Warragamba Dam Raising Project SSI-8441

Submission by Ted Woodley¹

17 December 2021

Figure 3-2. Relative contribution different river catchments in range of Hawkesbury-Nepean Valley floods

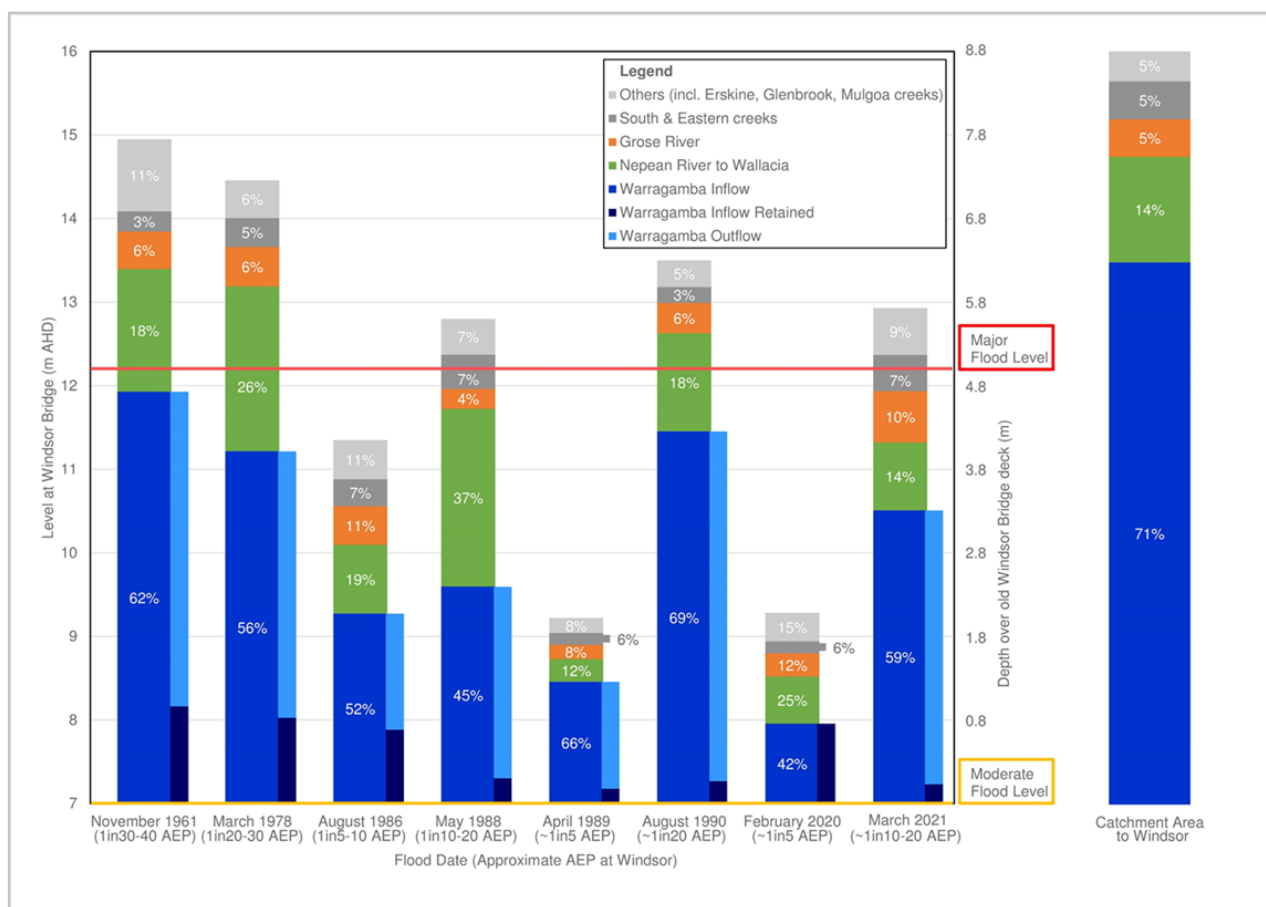
“The large Warragamba Dam catchment historically contributes up to 70 percent of flows during flooding in the Hawkesbury-Nepean (see Figure 2).”

This statement is repeated throughout the EIS, but it is highly misleading and beside the point.

Figure 2 shows relative contributions from the Warragamba catchment for the eight largest floods in the sixty years since the Dam was commissioned. The Figure focuses on Warragamba inflows from its catchment (dark blue bars).

But inflows are irrelevant as far as downstream flooding is concerned, as is the ‘up to 70%’ contribution quote.

The only relevant contribution to flooding is the outflow from the Dam to the Valley (light blue bars), which is obviously less than the inflow by the amount retained in the Dam (black bars) – i.e. the spare capacity in the Dam at the time.

Figure 2 indicates that outflows from Warragamba Dam during the eight floods contributed 0% to

65% to downstream flooding, averaging slightly less than half:

- Warragamba Dam did not contribute at all to the February 2020 flood, as the Dam did not spill – it was at less than 50% capacity at the time.
- The maximum contribution to flooding from Warragamba Dam occurred in the August 1990 flood, at around 65%.
